Modification Request for Sydney Adventist Hospital, Wahroonga Education Centre (MP10_0070 MOD 4)

Urban Design Assessment

MP10_0070 MOD 4

Report Date: 24.07.2013

1 SITE PLAN
12017 DA 01c.ph
SCALE 1:500

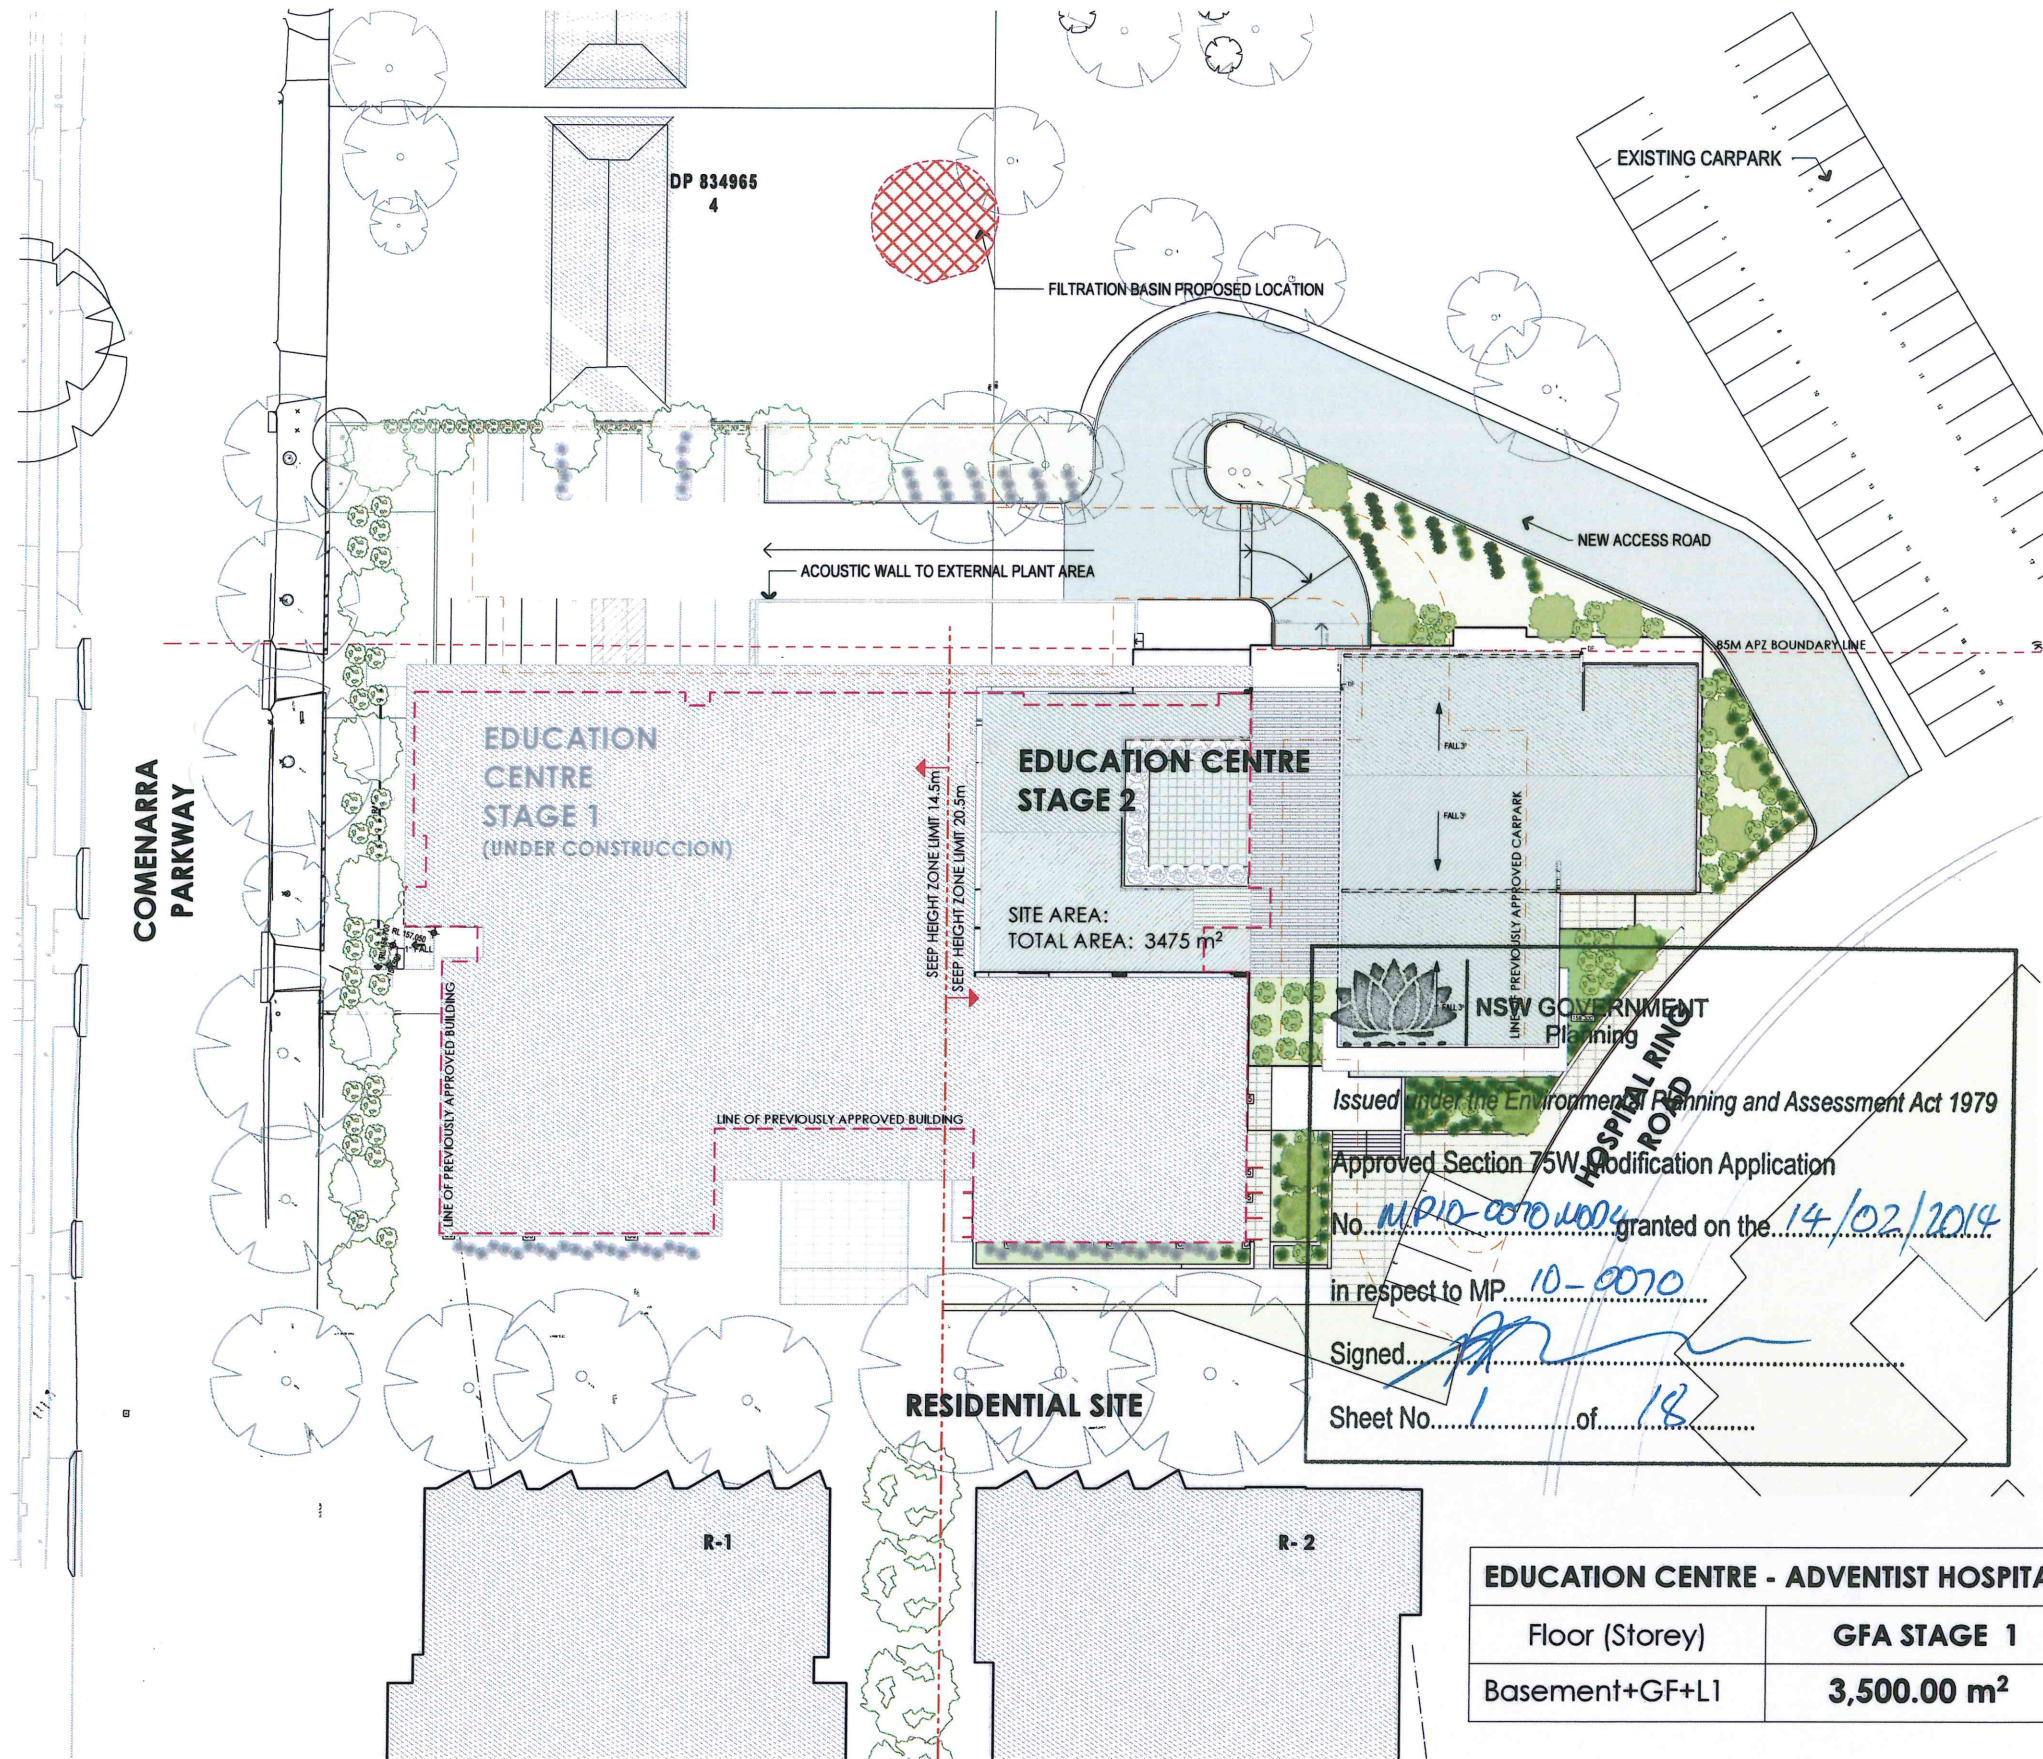
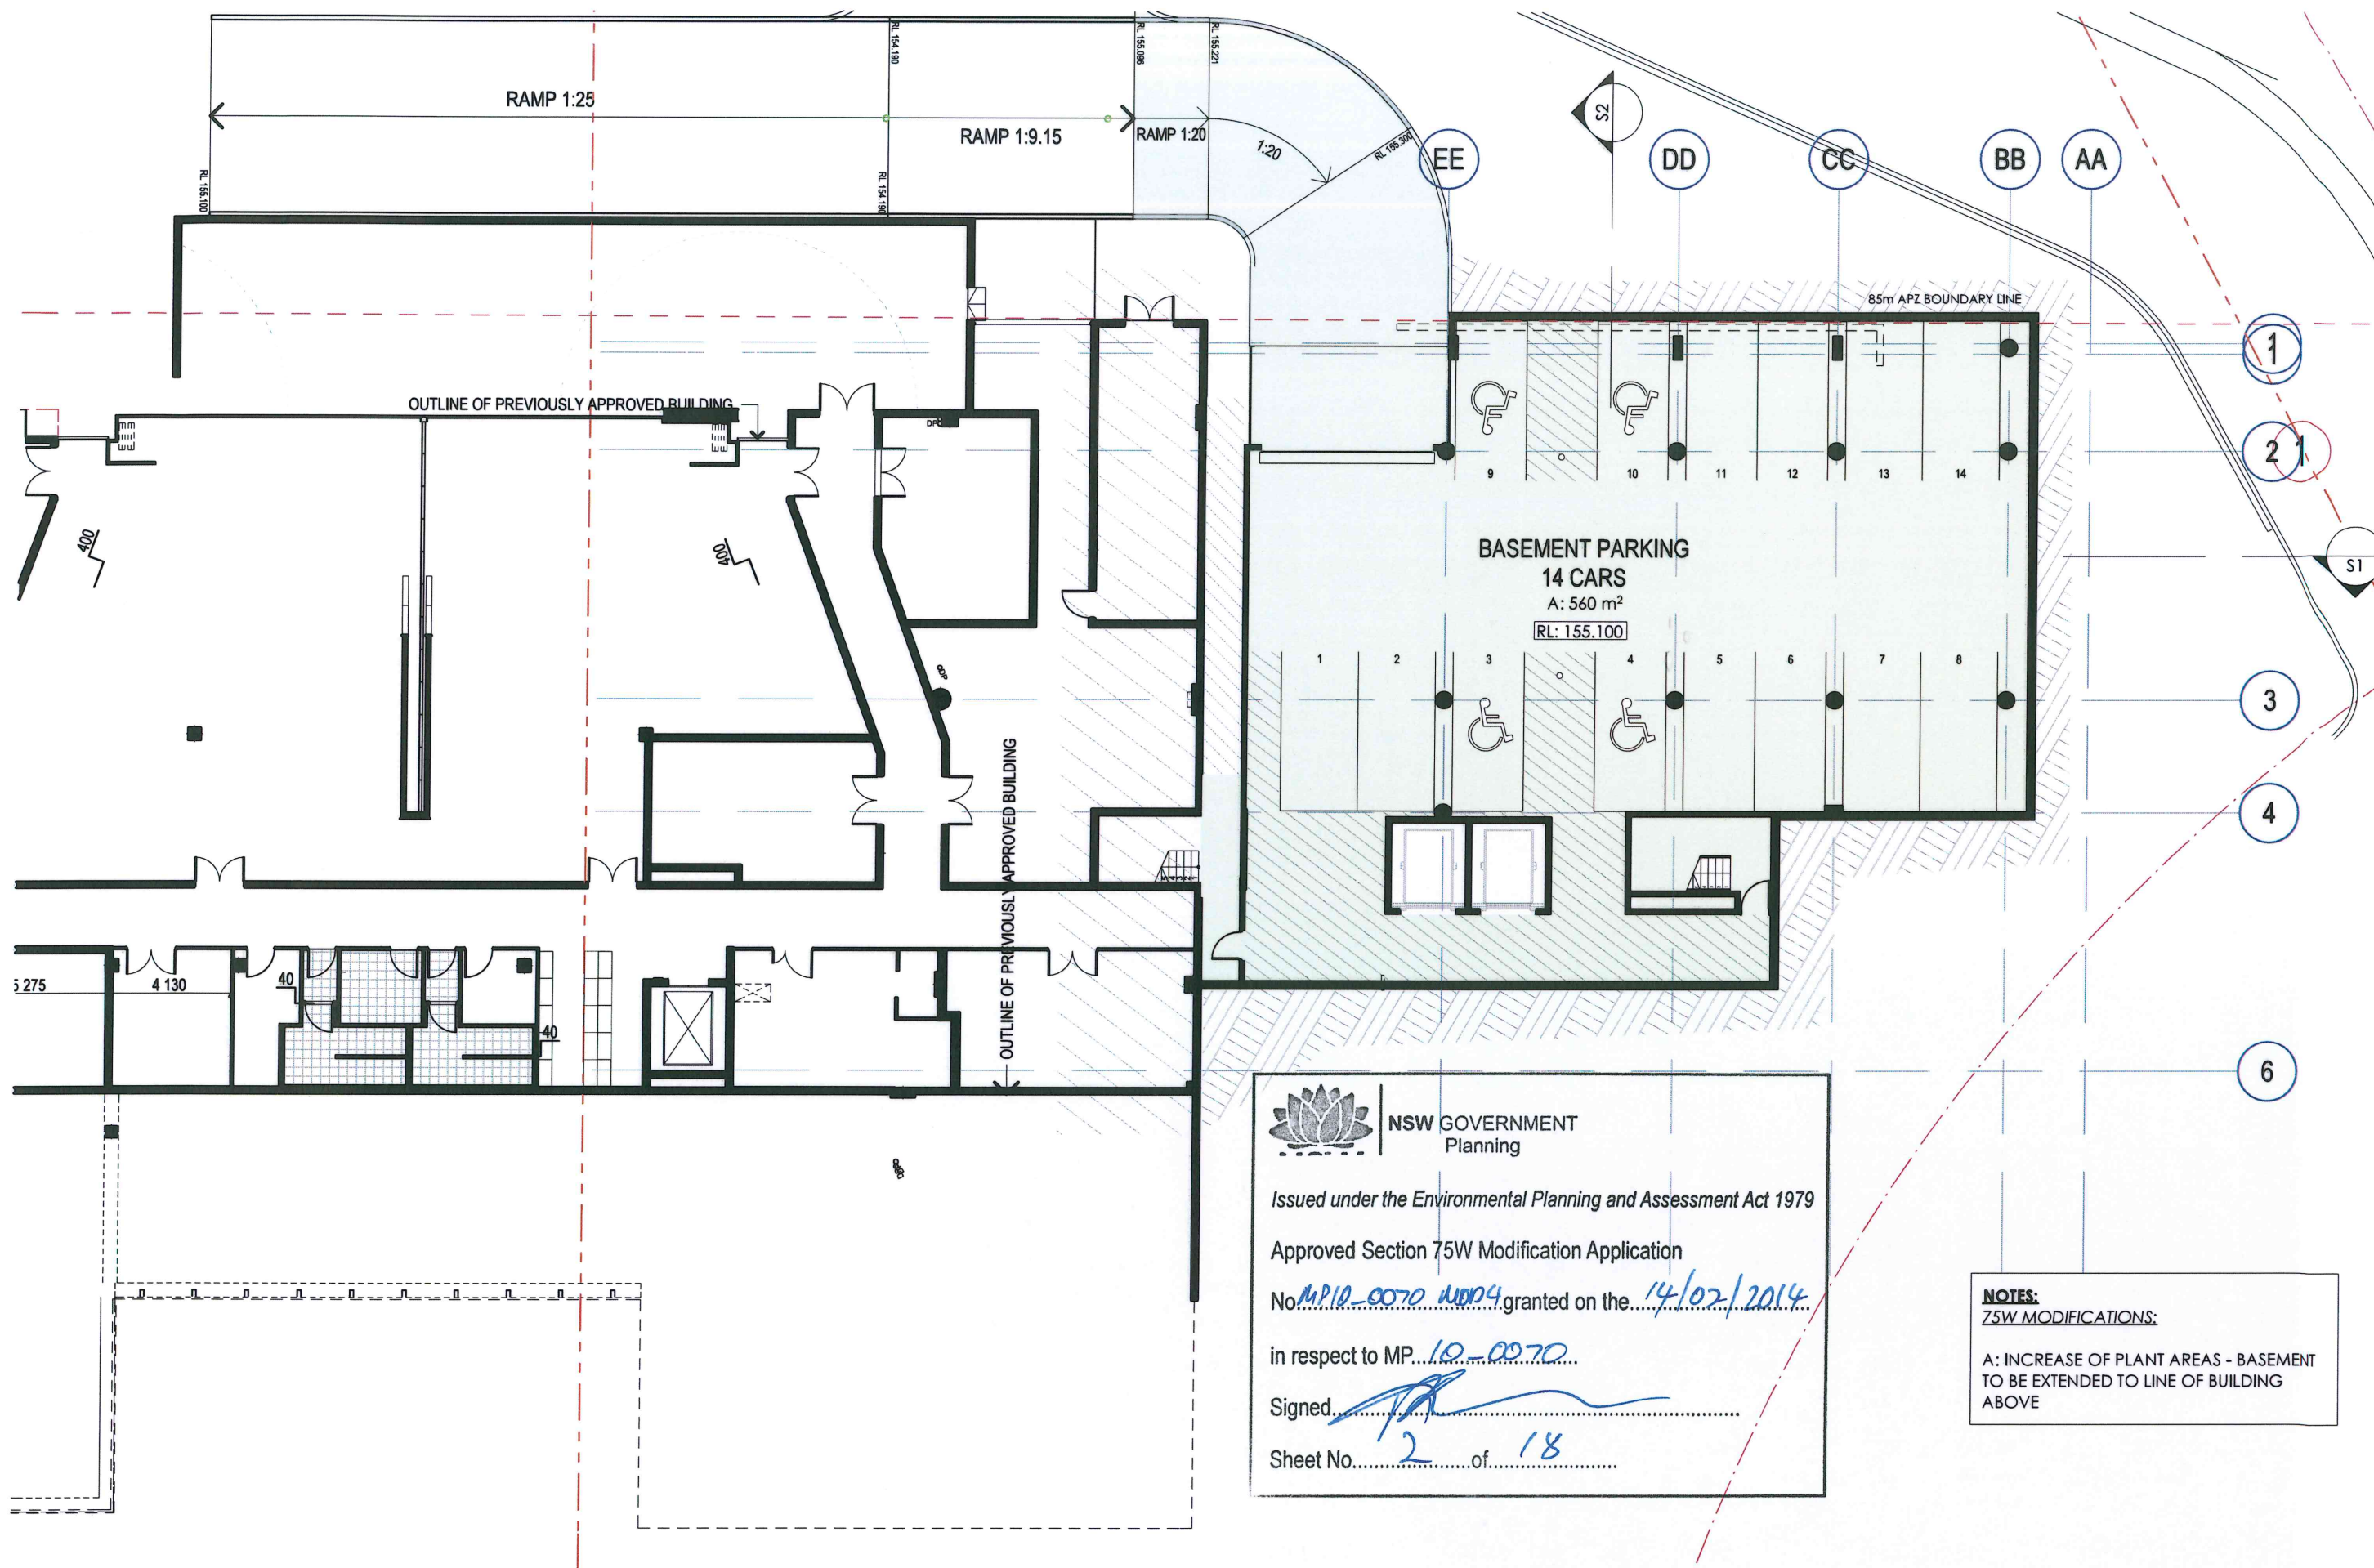
- The cumulative impact to public domain space in this MOD 4 application has not been considered. For example the provision of a north facing open space that provided an entry and spill-out area for the education centre is not possible with the proposed additional building footprint. There is no indication of where this space is replaced, particularly as the proposed variation is seeking to double the floor space and thus capacity of the Education Centre and hence need for outdoor recreation areas. This has a direct bearing on the response for the adjoining student residential site and connecting spaces to the Mixed Use Neighbourhood Centre that must be addressed.

The MOD 3 approval to alter the footprint is to be submitted in order to assess the cumulative impact to public domain space in this MOD 4 application. At question is whether there could have been a north facing open space that provided an entry and spill-out area for the education centre that has been lost with the proposed additional building footprint. If so, where is this space replaced, as it must, given the proposed variation is seeking to double the floor space and thus capacity of the Education Centre. This has a direct bearing on the response for the adjoining student residential site and connecting spaces to the Mixed Use Neighbourhood Centre that must be addressed.

The additional entry at the north-east corner is supported in principle but needs to be placed in context of what the entry relates to beyond the site. There appears to be no designated footpaths along the Hospital Ring Road linking this entry to the neighbouring student residential site nor to the adjoining Hospital Precinct which may be expected to draw significant pedestrian traffic.

WEST ELEVATION FINISHES

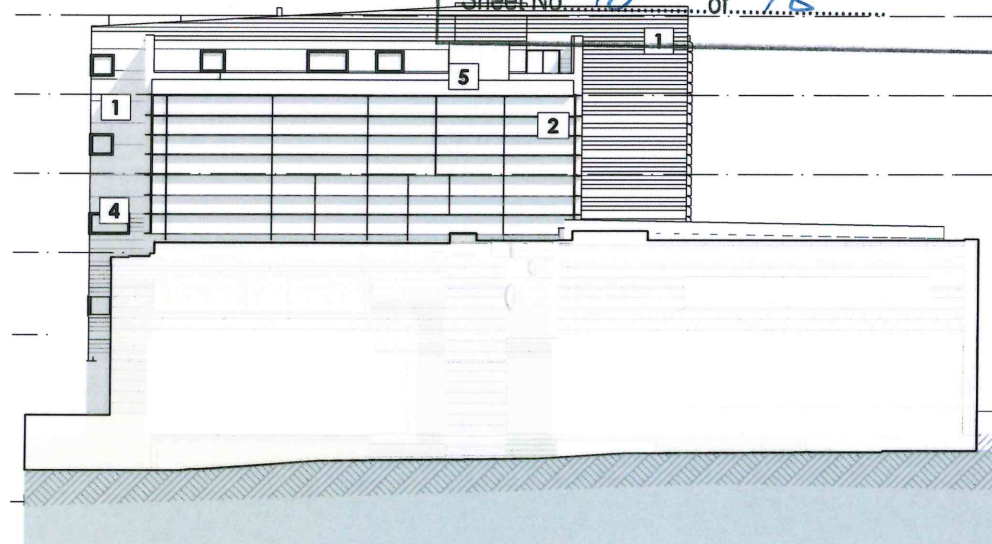
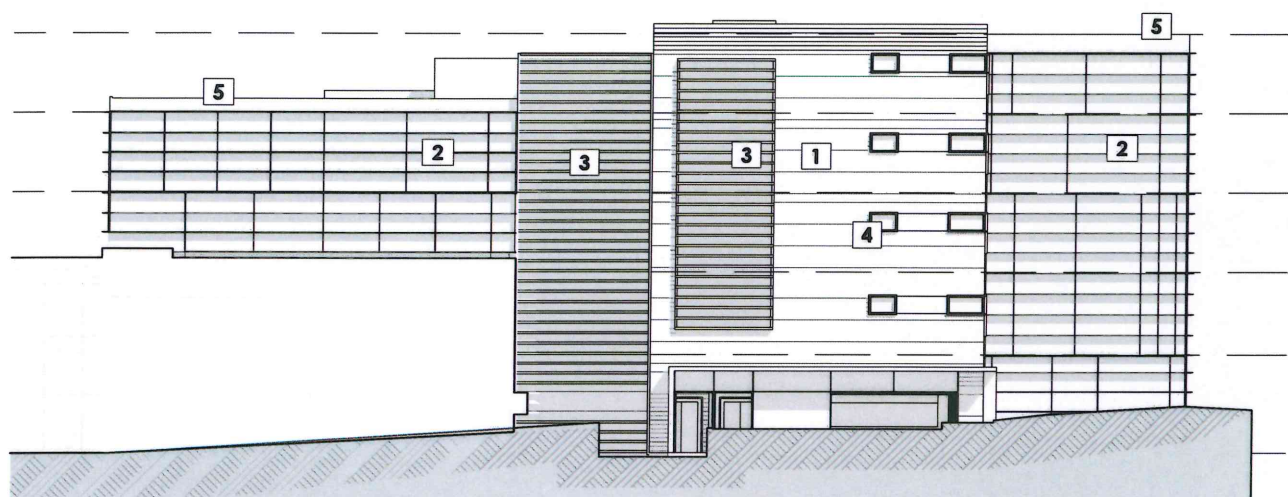
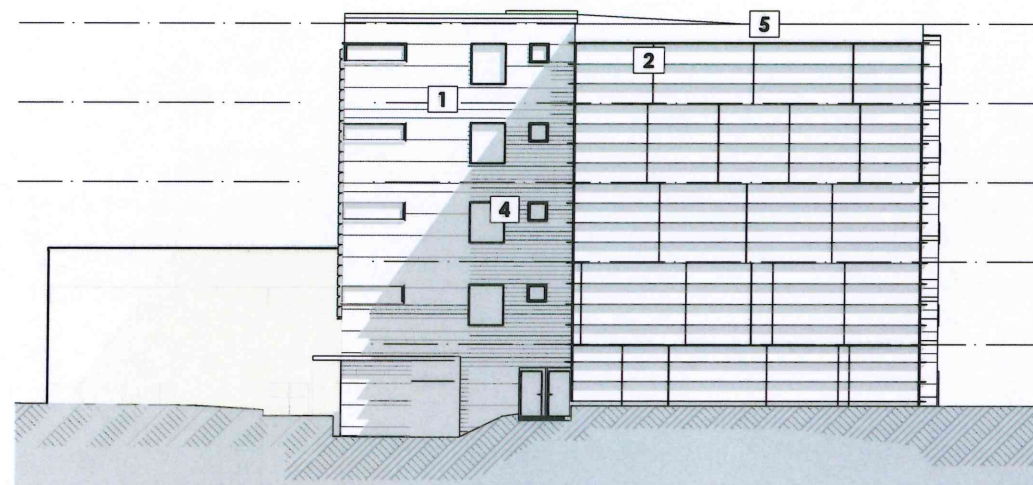
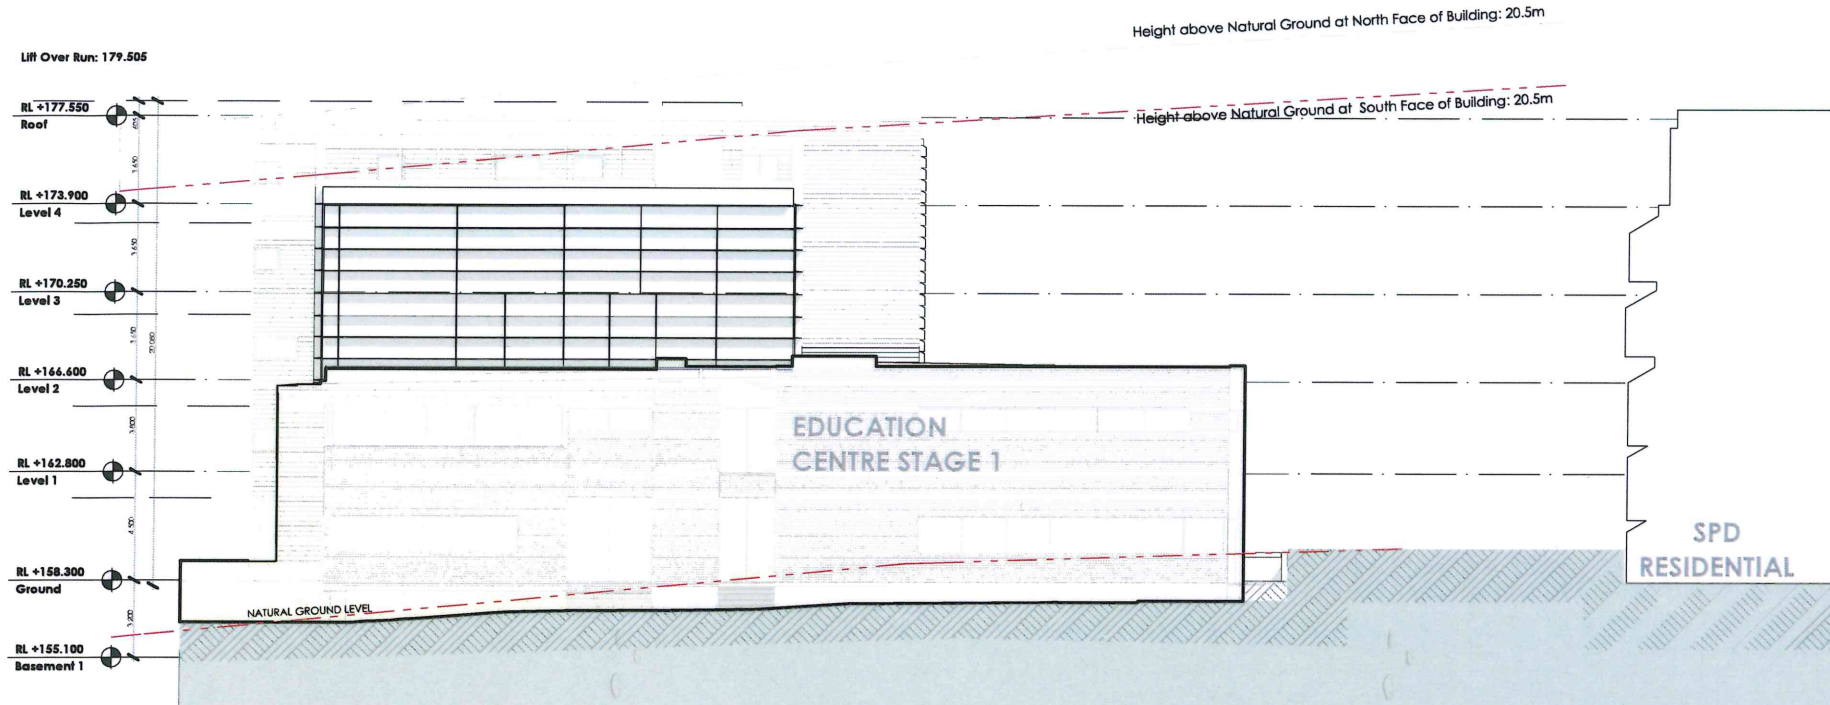
The long axis of the building is sited north-south creating heat loads along the long western, and to a lesser extent, eastern facades, with consideration also required for the northern floor to ceiling curtain wall.

Smaller window openings are proposed in the exposed facades of the central aluminium clad more solid component. Shade protection and/or appropriately rated glazing will be required to protect these openings. It is unclear in submitted documents what protection has been provided.

Likewise, the proposed glazed curtain wall elements have no physical solar protection indicated and no detailed information has been provided regarding the glazing selection. Section J Energy Efficiency provisions of the BCA will need to be demonstrated.
